**KIRKLEES METROPOLITAN COUNCIL
INVESTMENT & REGENERATION SERVICE**

**DELEGATED DECISION TO DETERMINE APPLICATIONS FOR
CONSENT, AGREEMENT OR APPROVAL REQUIRED BY CONDITION**

Reference No: 2018/44/92114/E

Site Address: Poplar Farm, Briestfield Road, Briestfield, WF12 0PA

Drawing No. 1541_14_B

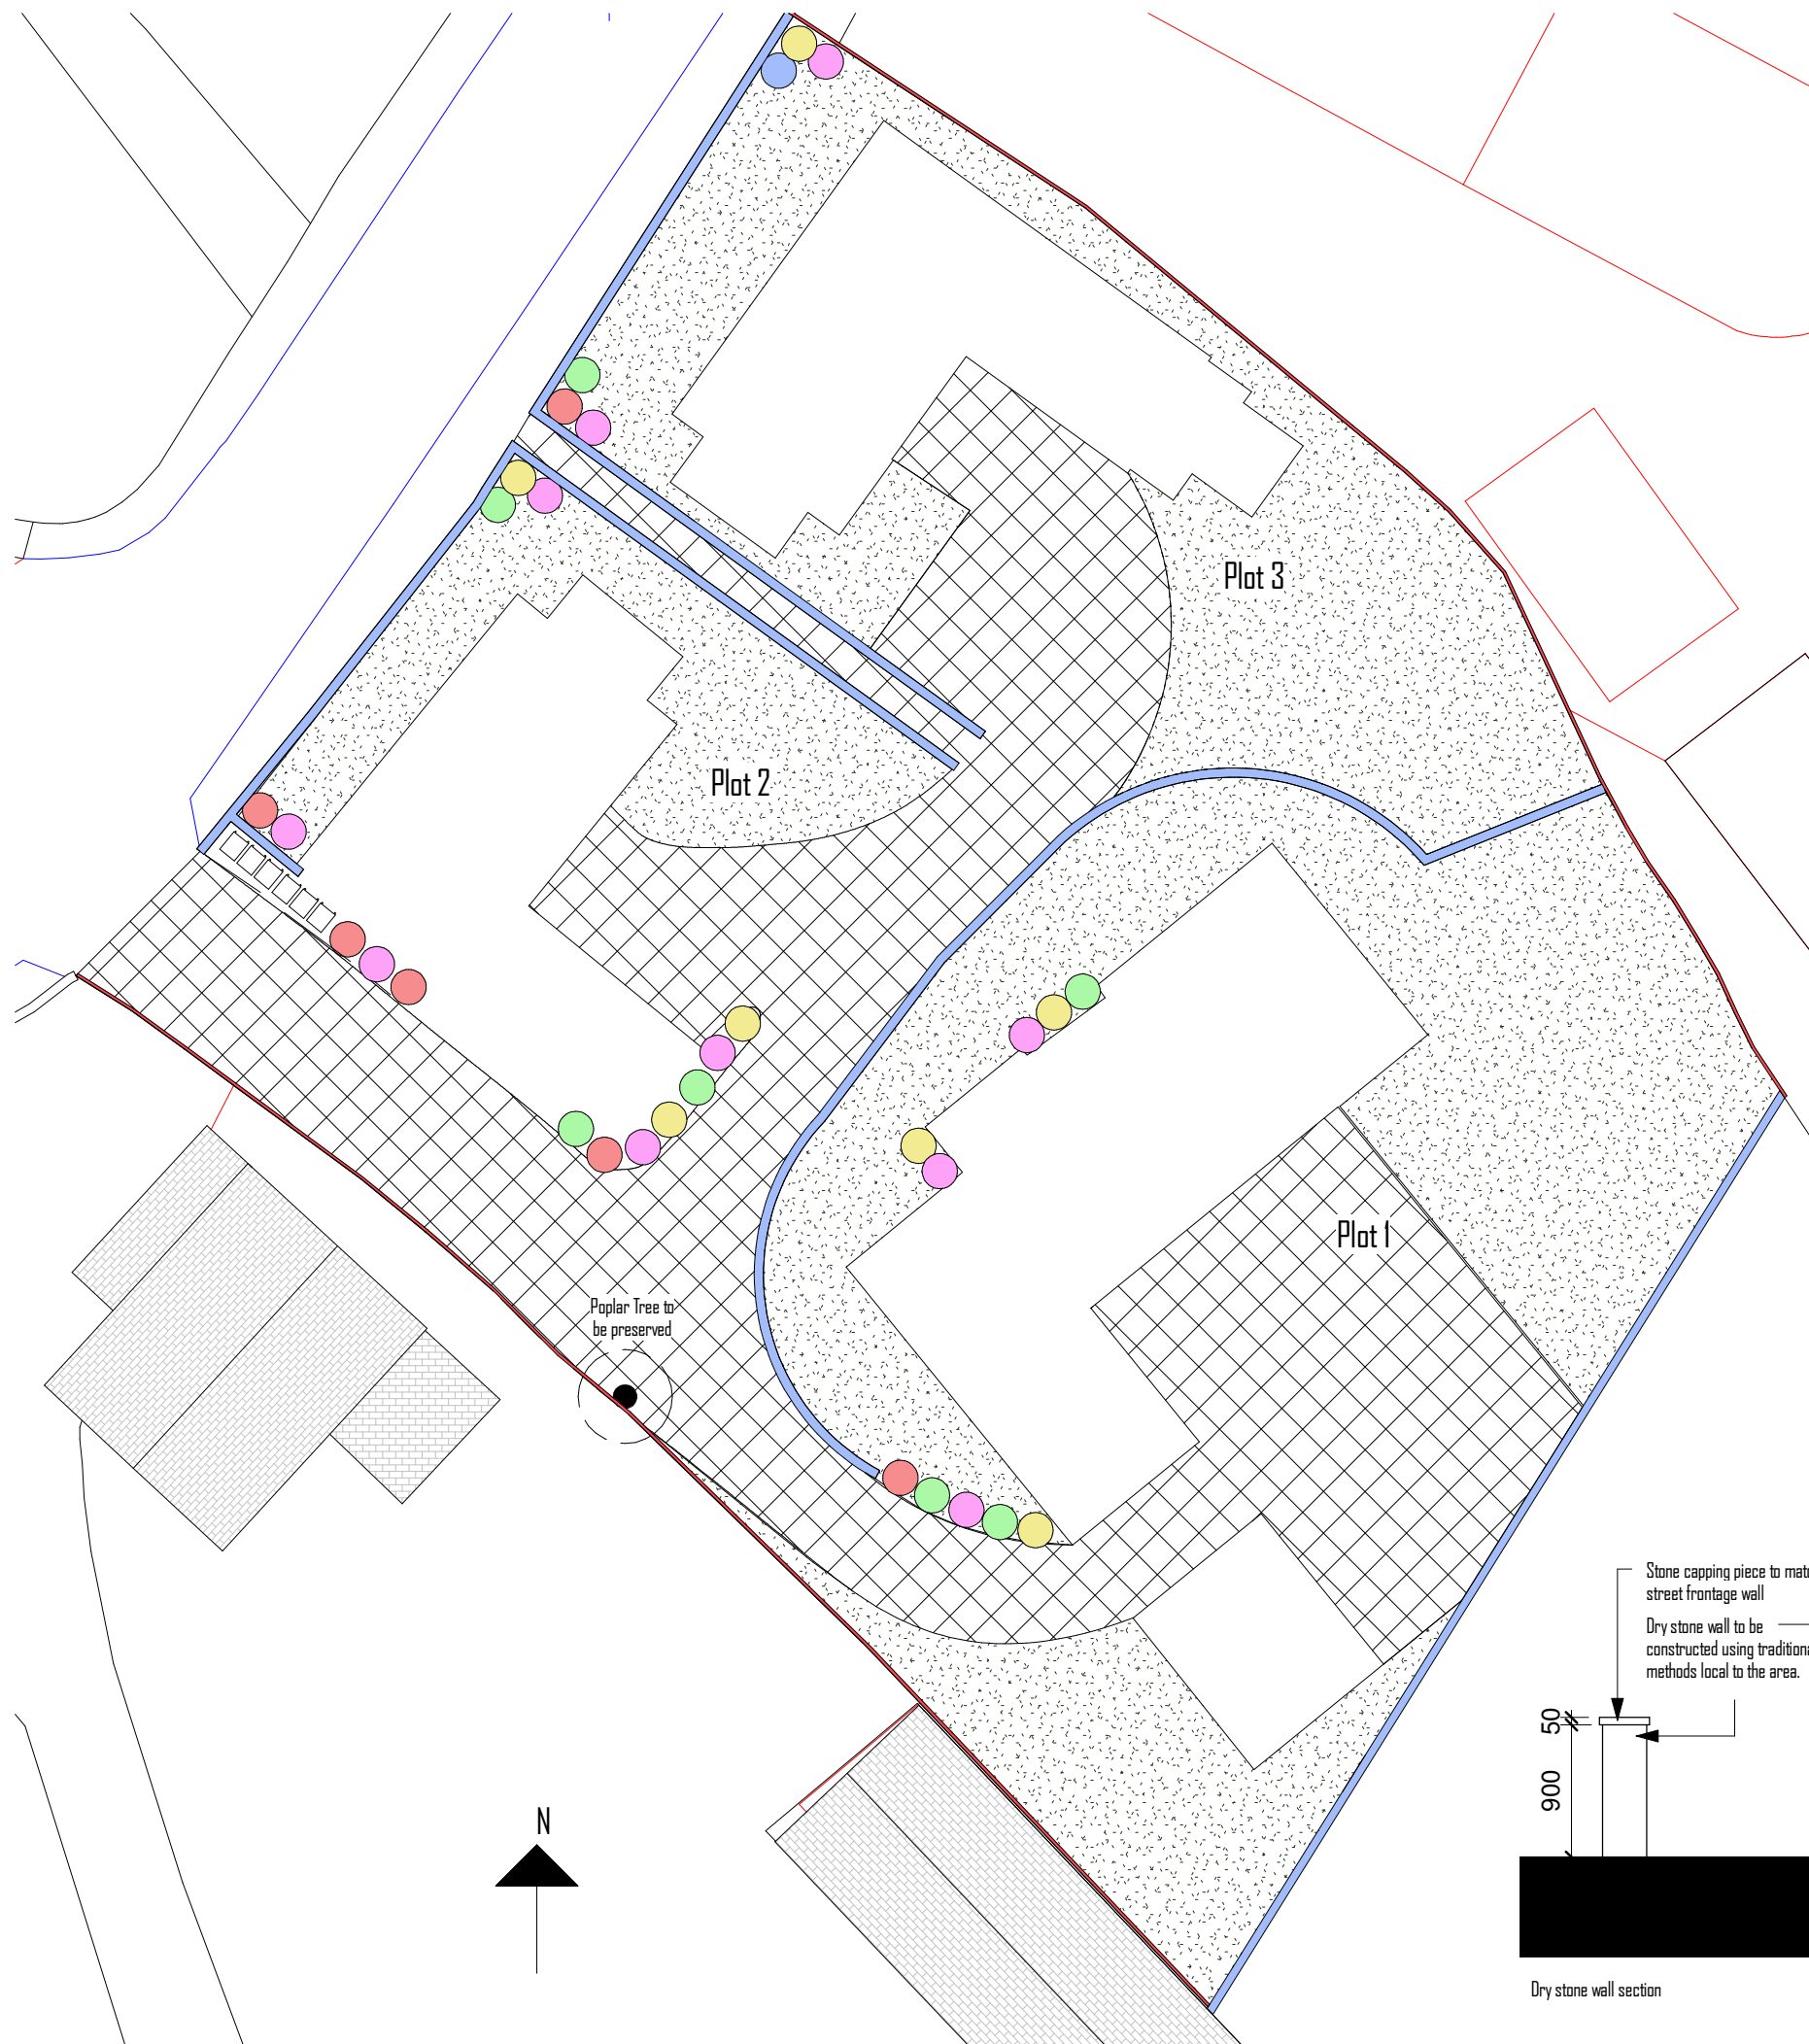
The submitted details show 0.9 metre high dry stone walling to the road frontage and rear elevations. The side boundaries would be 1.8 metre high close boarded fence. This is acceptable in terms of the Committee report.

These details are acceptable for the purposes of condition 13 subject to the following:

- Notwithstanding the sections shown on the above drawing the boundary walls shall be drystone with a traditional coping and of the same stone agreed under condition 4 above. If any other material is to be used this must be agreed with this Authority beforehand.
- The boundary treatment shall be erected maintaining the visibility splays required under condition 10 of the planning permission.

**Drawing No.** 1541\_14\_D

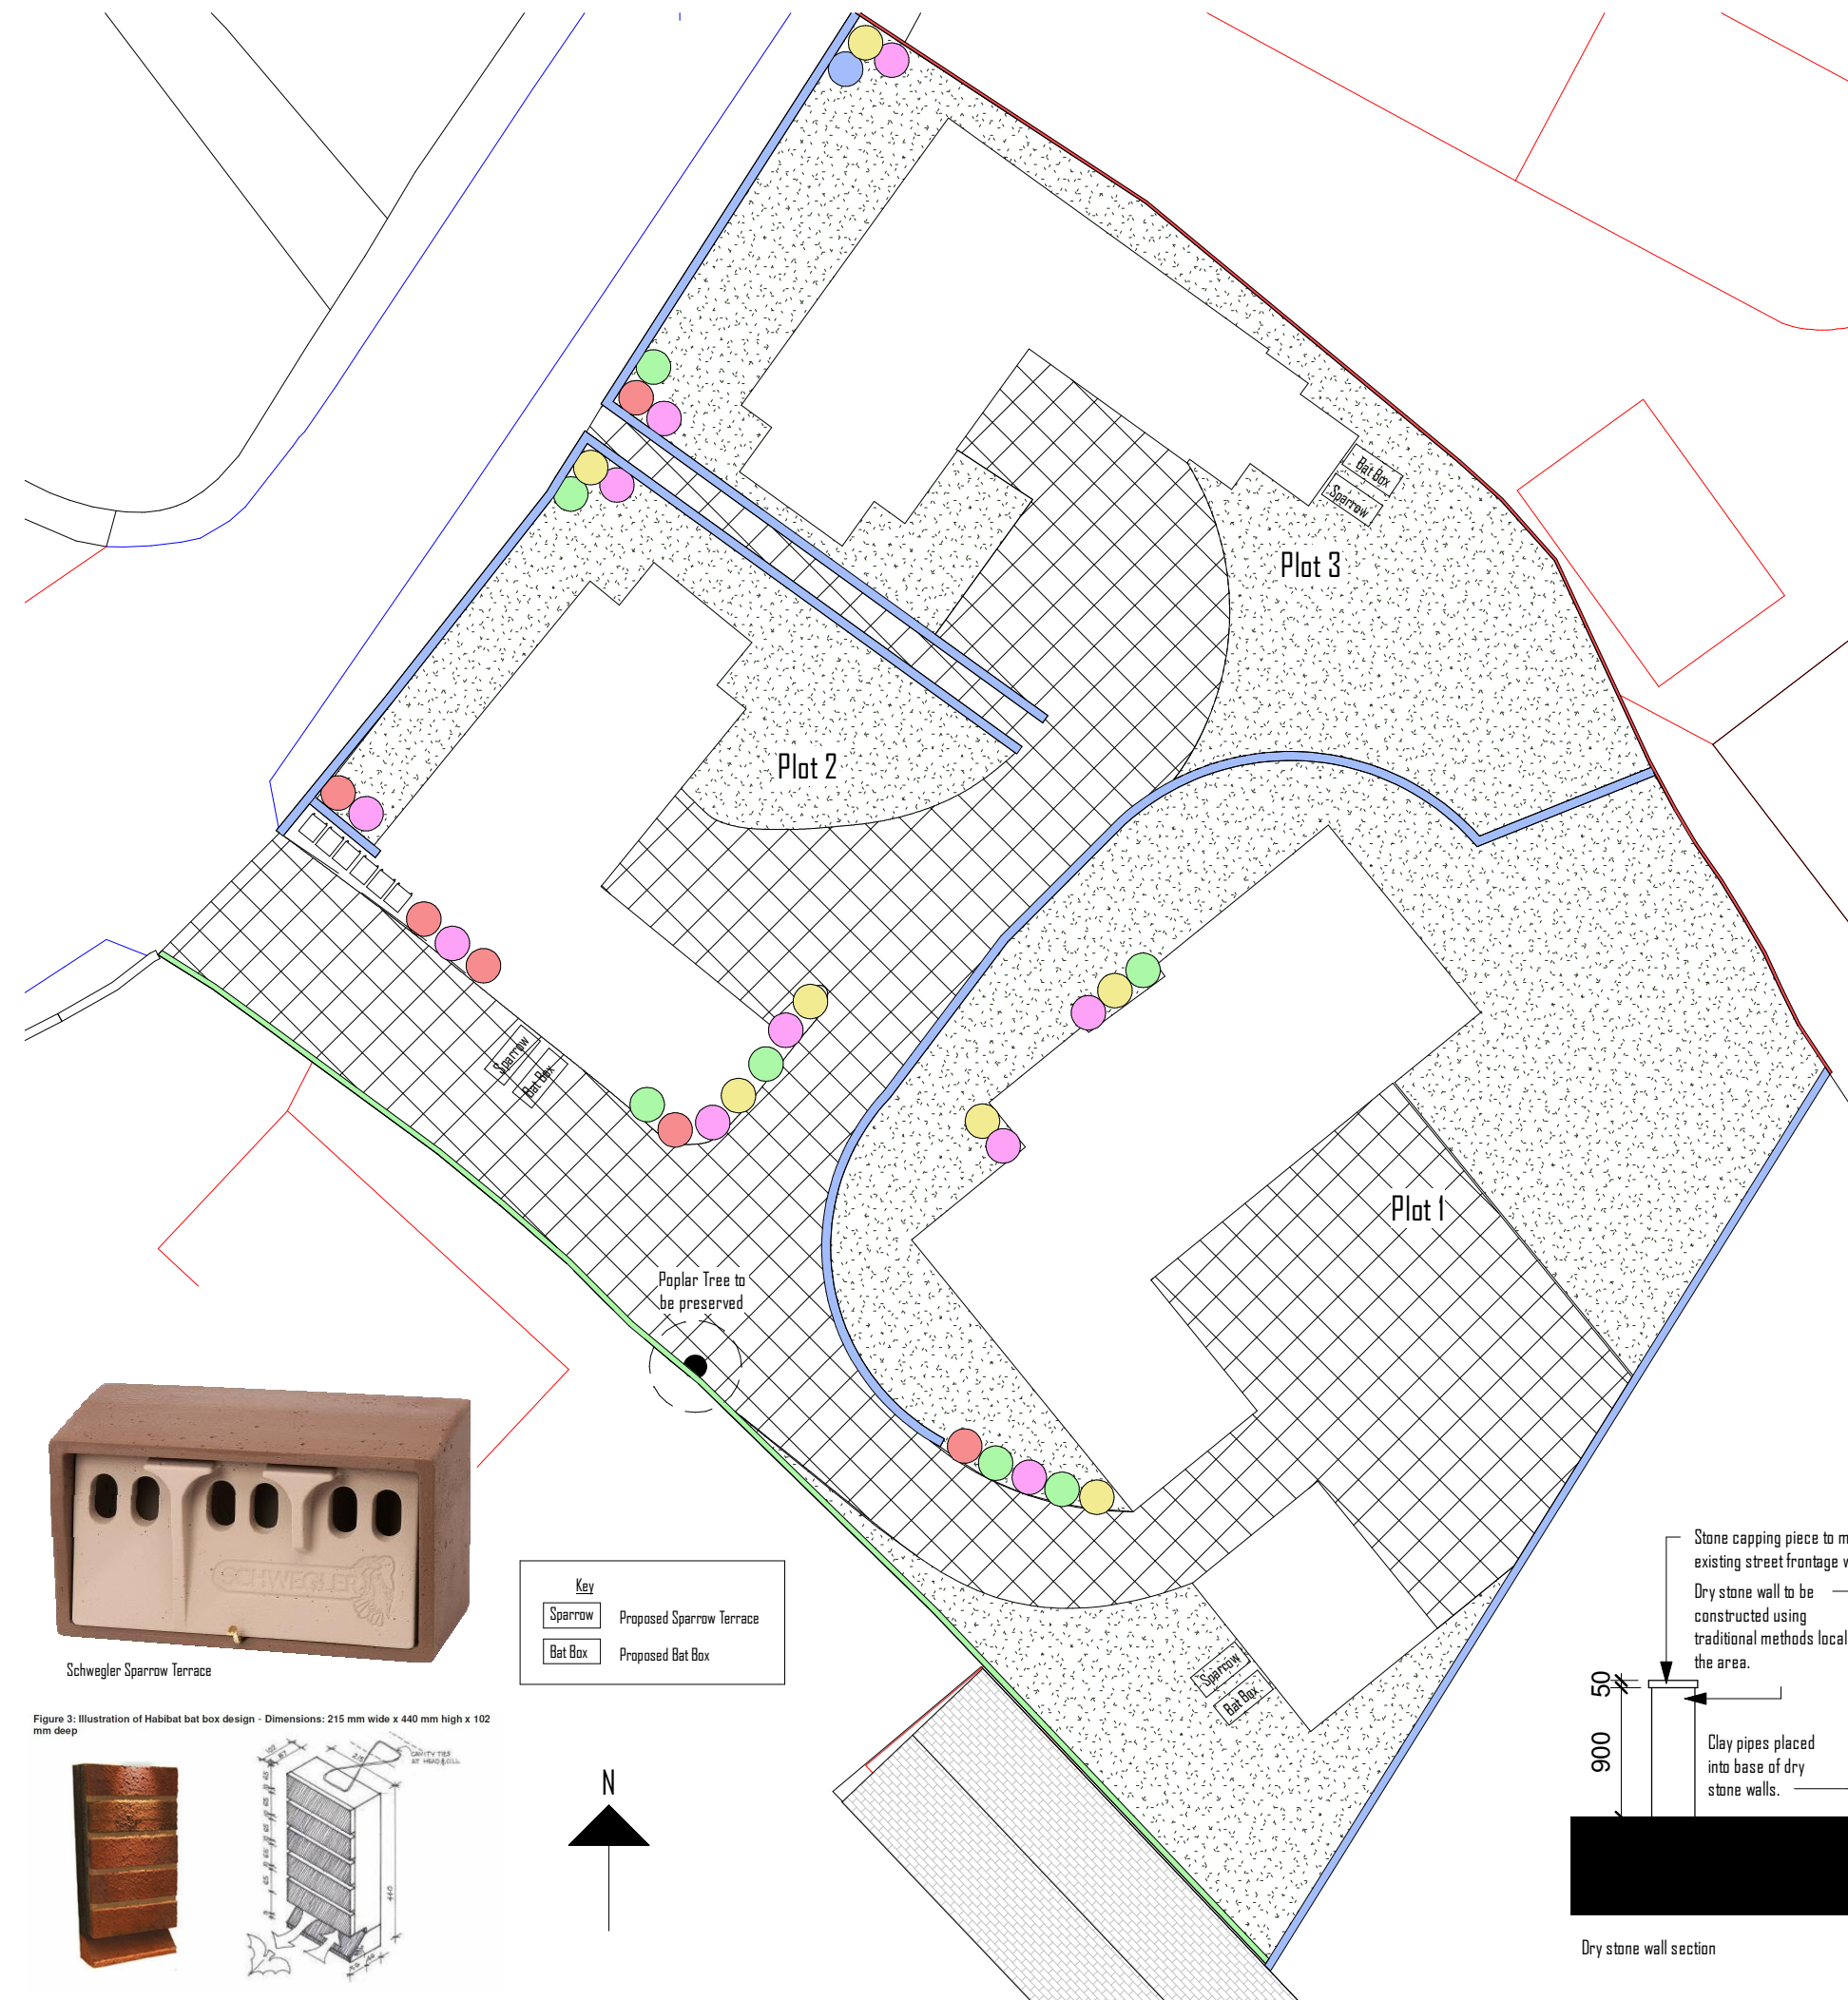
As noted in my e-mail of 22 August 2018 the submitted Landscape Management Plan does not address ecological issues. In such circumstances the condition cannot be discharged. These details can be submitted as part of the current application but are required within three weeks from the date of this letter.
